2005-0120

Relocation of House

RE: Application for Single Family House Relocation, Brewer Street, ID # 2005-0120

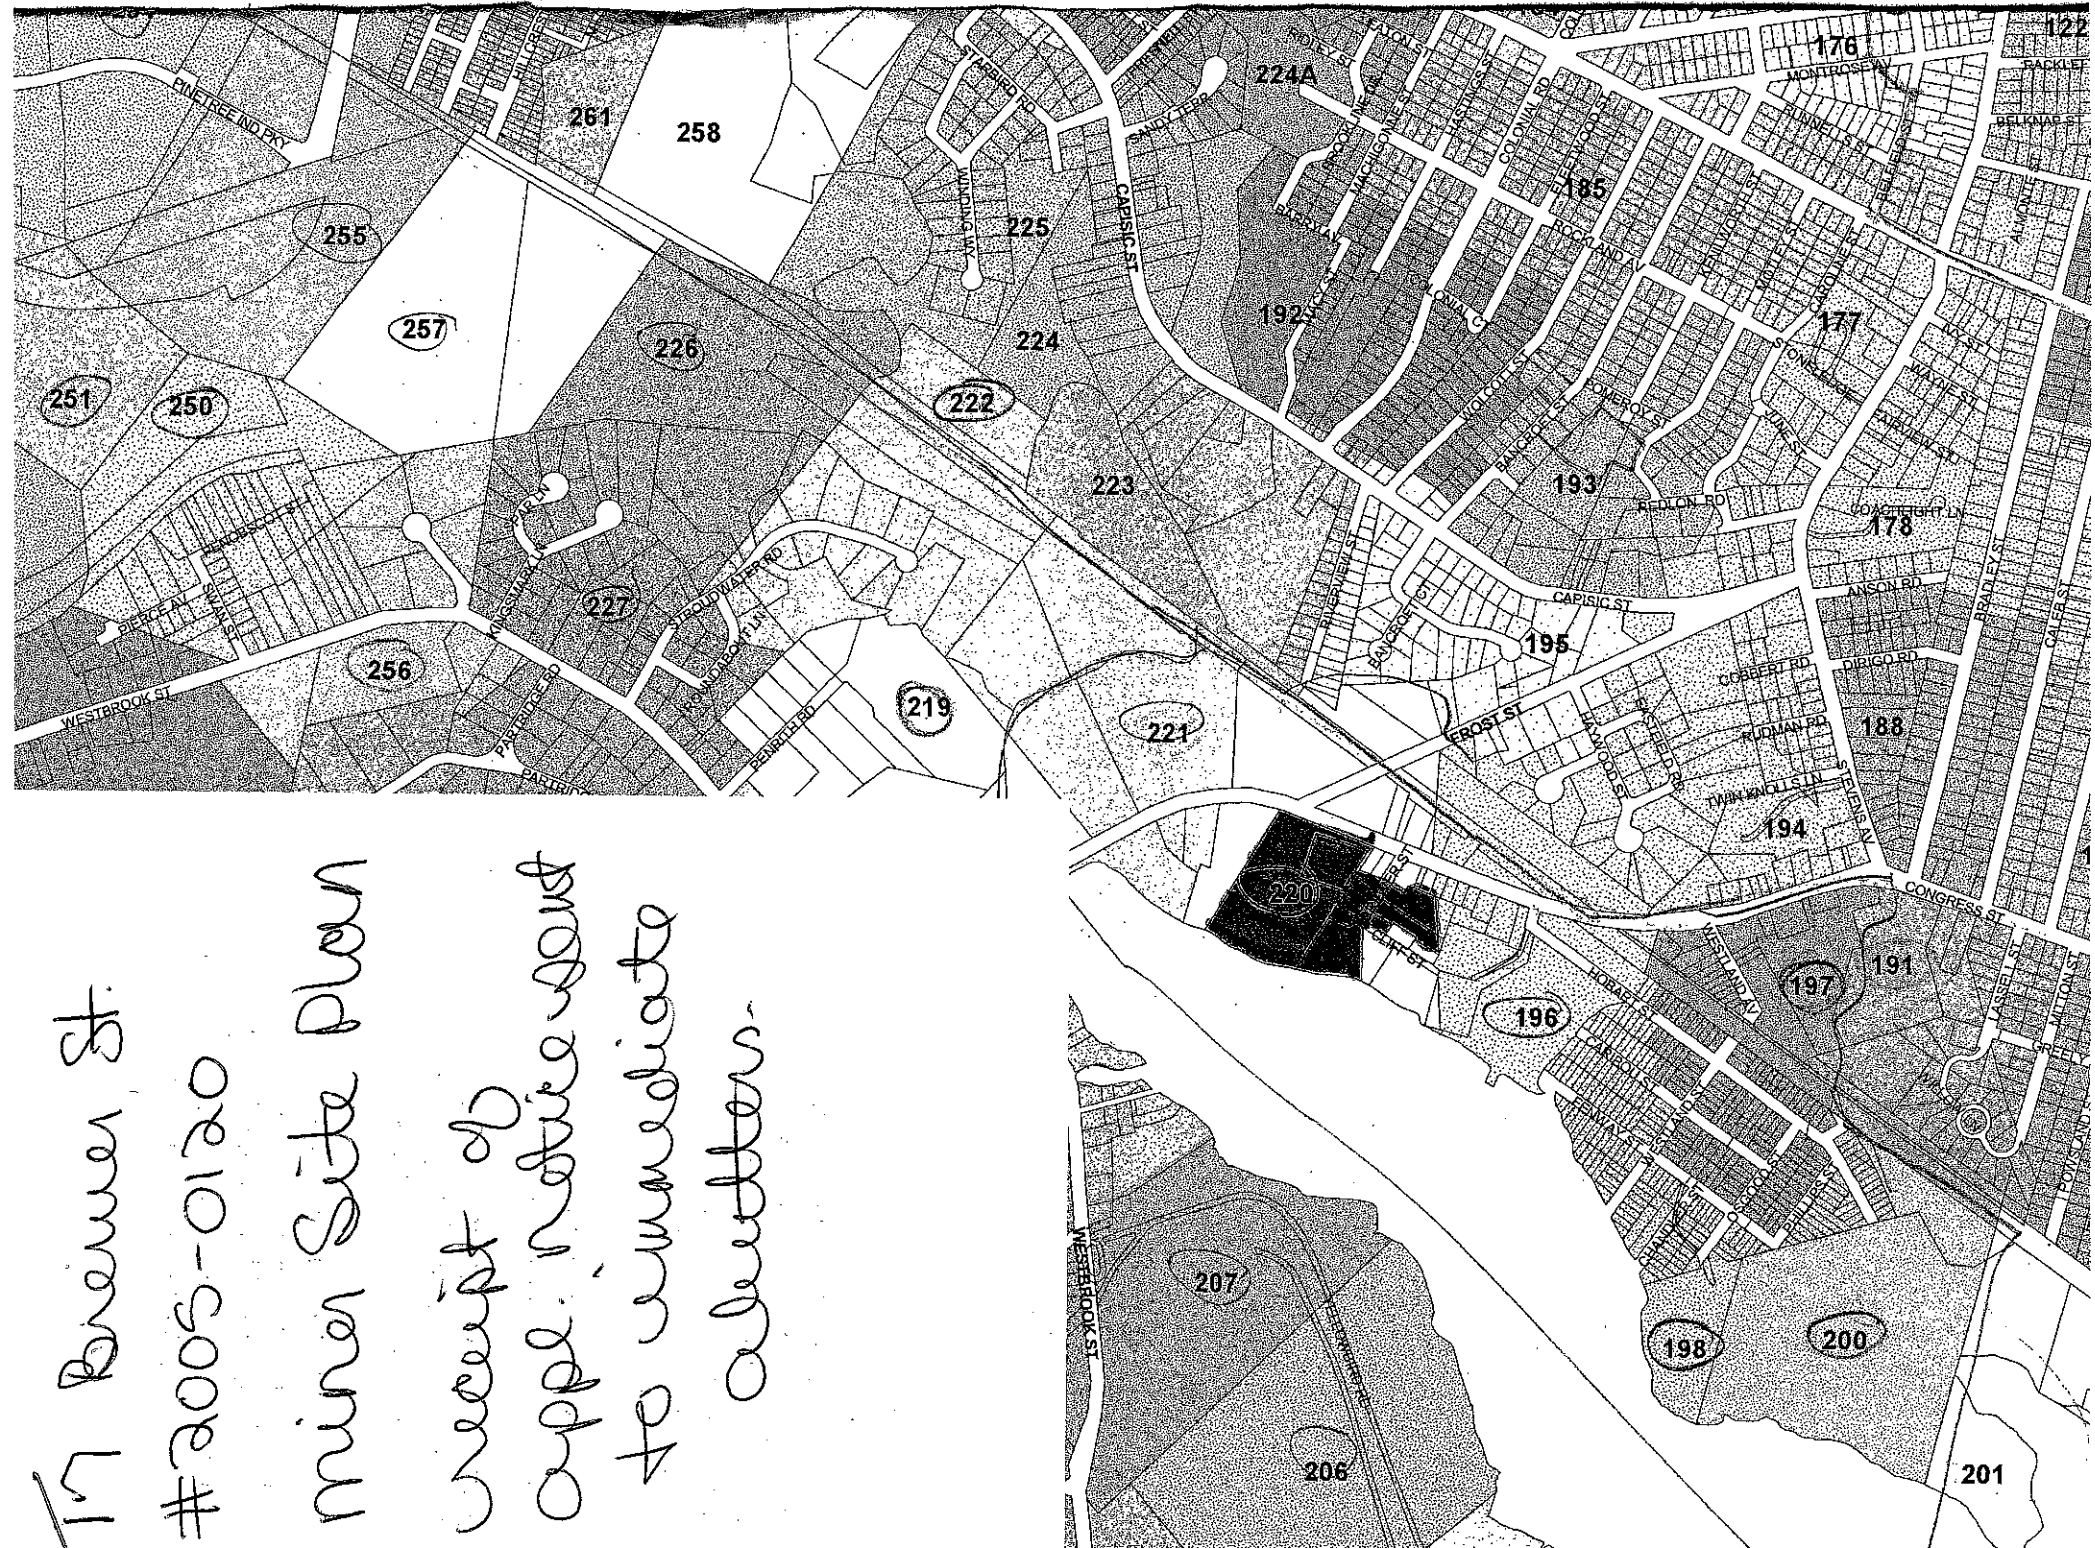
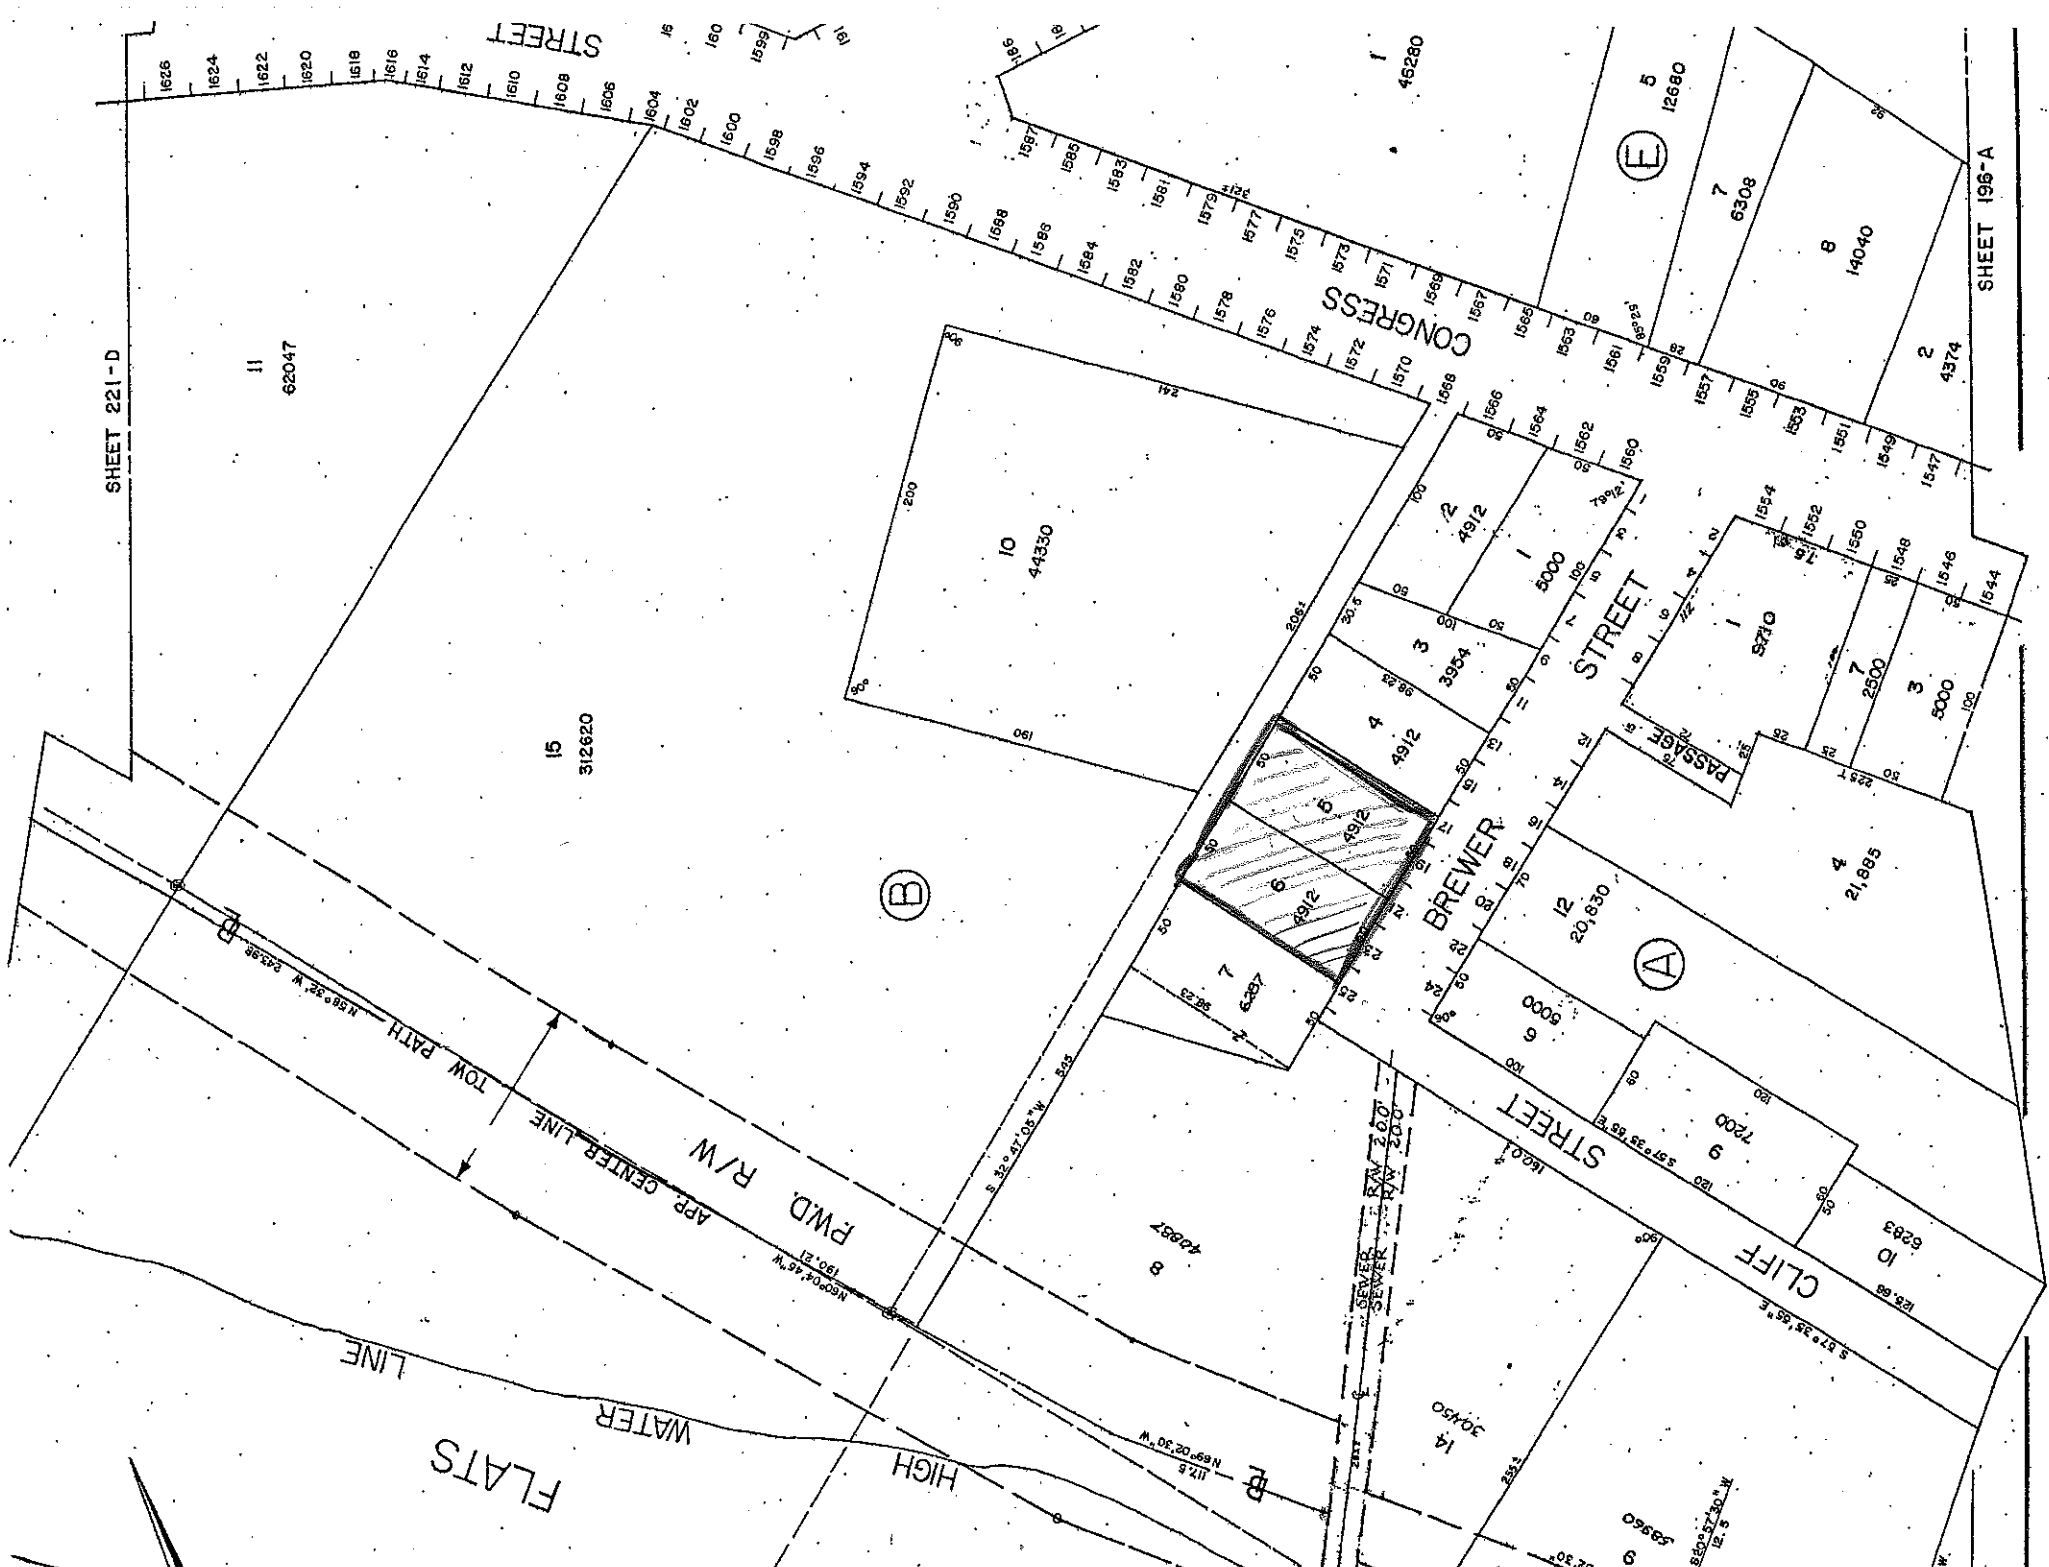
1. 4 parking spaces, 9'x19' each, are required (2 per unit). Please add 4th space to the site plan. Note: parking in the R-5 zone must be outside of the front setback.
2. Relating to item #1, it may be possible to add the 4th space in front of the garage and eliminate the proposed curb cut and paved driveway in front of the new building. Please consider.
3. Please show proposed topography/grading on your site plan.
4. Add erosion control (silt fence) as applicable.
